Phone: 0300 123 6780
Email: Kathryn.Walsh@lancashire.gov.uk
Your ref: 3/2025/0039
Our ref: 3/2025/0039/HDC/KW
Date: 19 March 2025

Location: Dilworth Cottage Ward Green Lane Longridge PR3 2ZL
Proposal: Proposed demolition of existing dwelling and erection of new two-storey detached dwelling with rooms in the roofspace. Installation of Air Source Heat Pump and Solar Panels.
Grid Ref: 362793 437734

Lancashire County Council acting as the Local Highway Authority has concerns regarding the proposal and does not consider that the application as submitted fully assesses the highway impact of the proposed development as set out in this response.

DRAWING TITLE
Proposed Plans

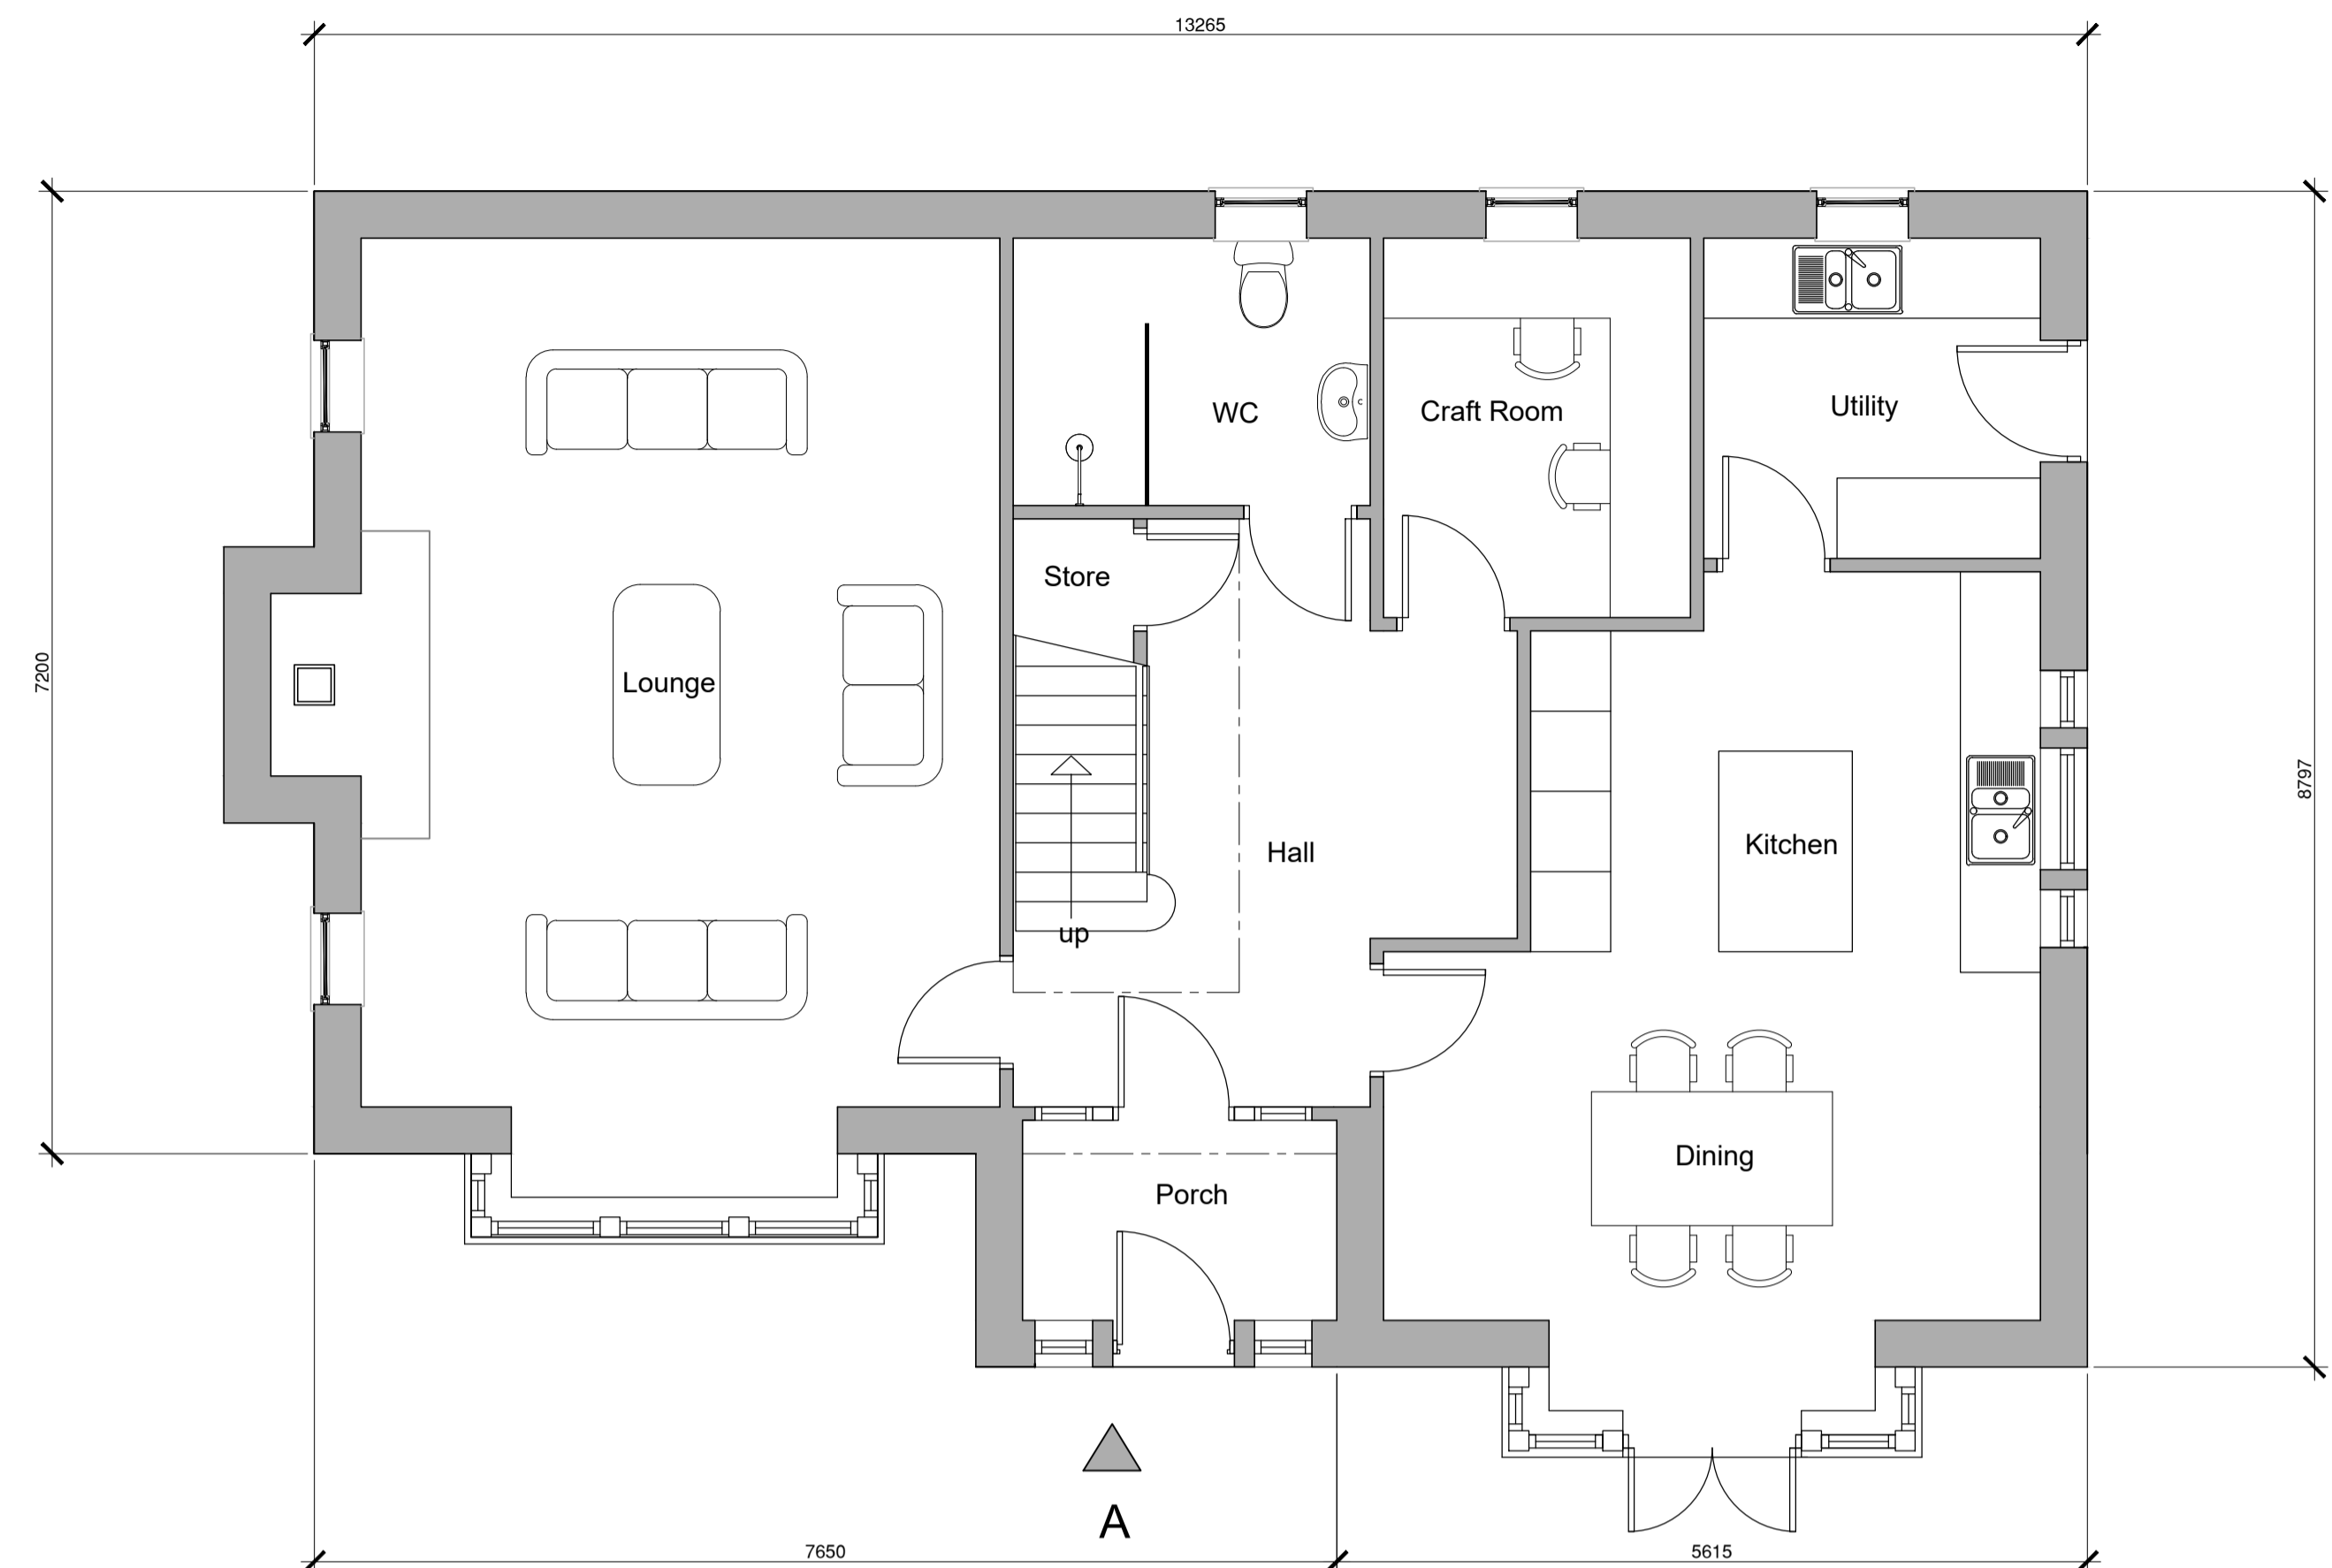
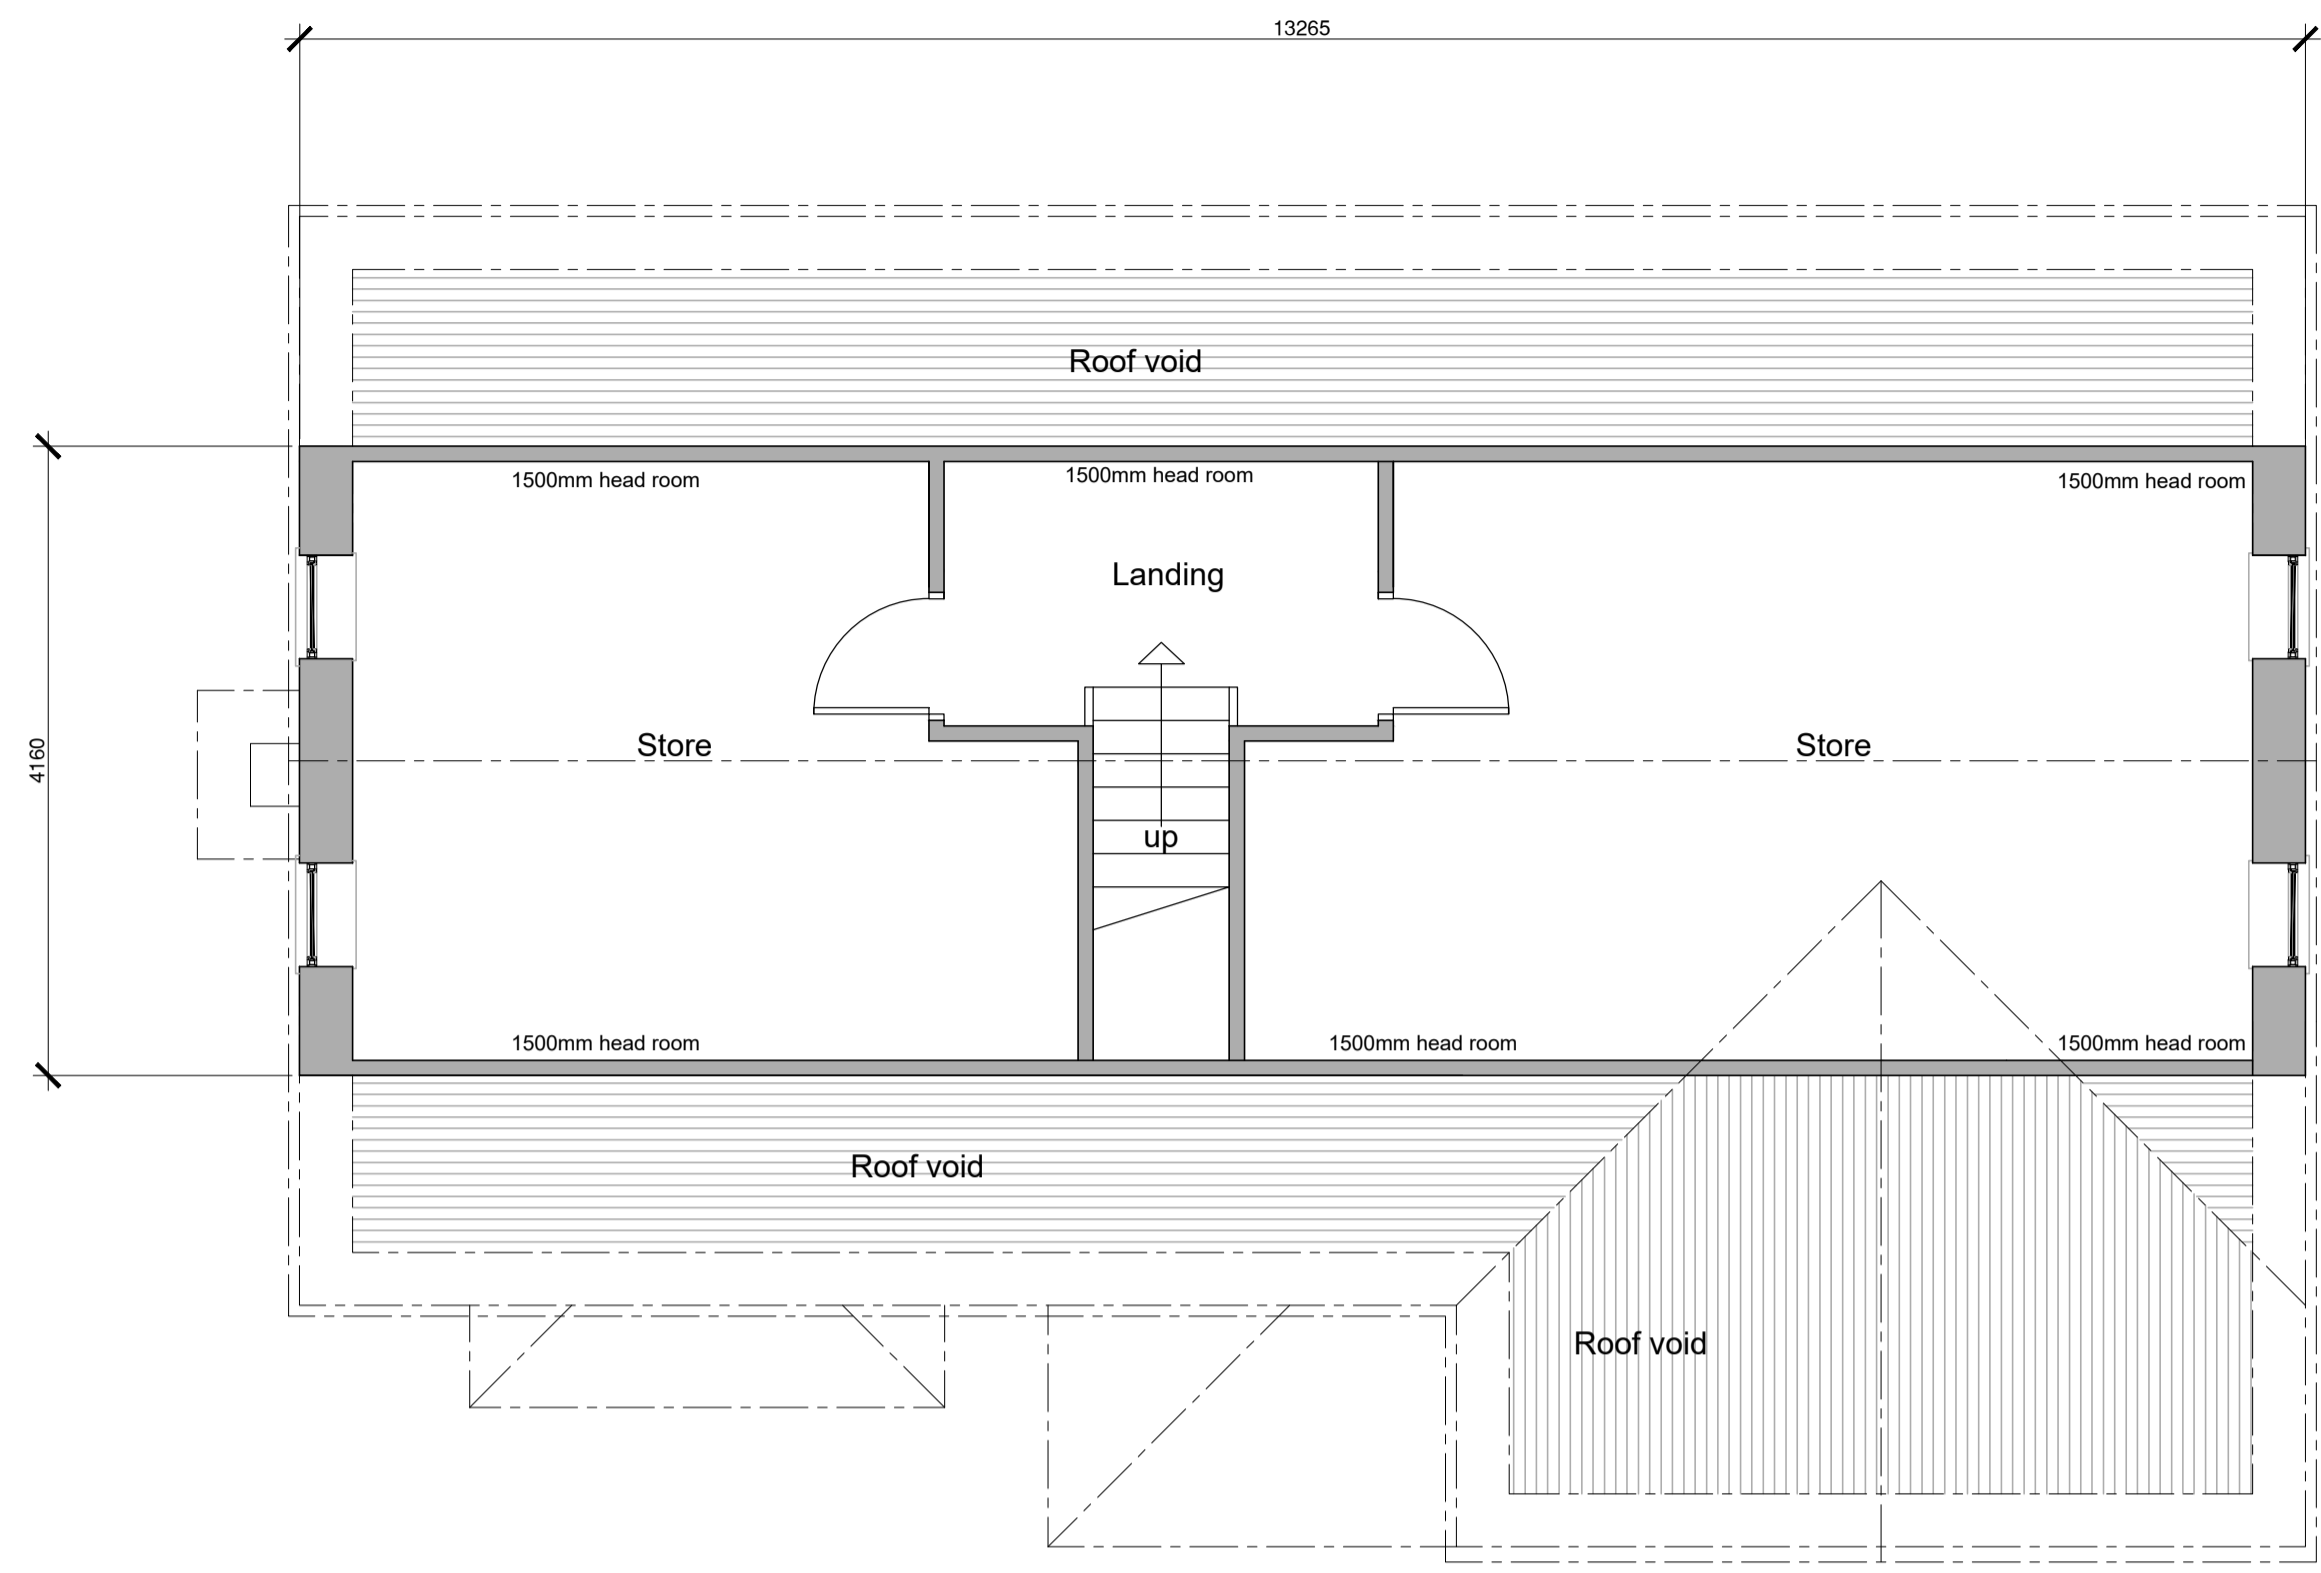
Whilst there is an existing double garage it does not meet the recommended minimal internal dimensions for a double garage which is 6m in length and 6m wide. Where double garages are smaller than the recommended minimum internal dimension of 6 x 6m they should not be counted as a parking space.
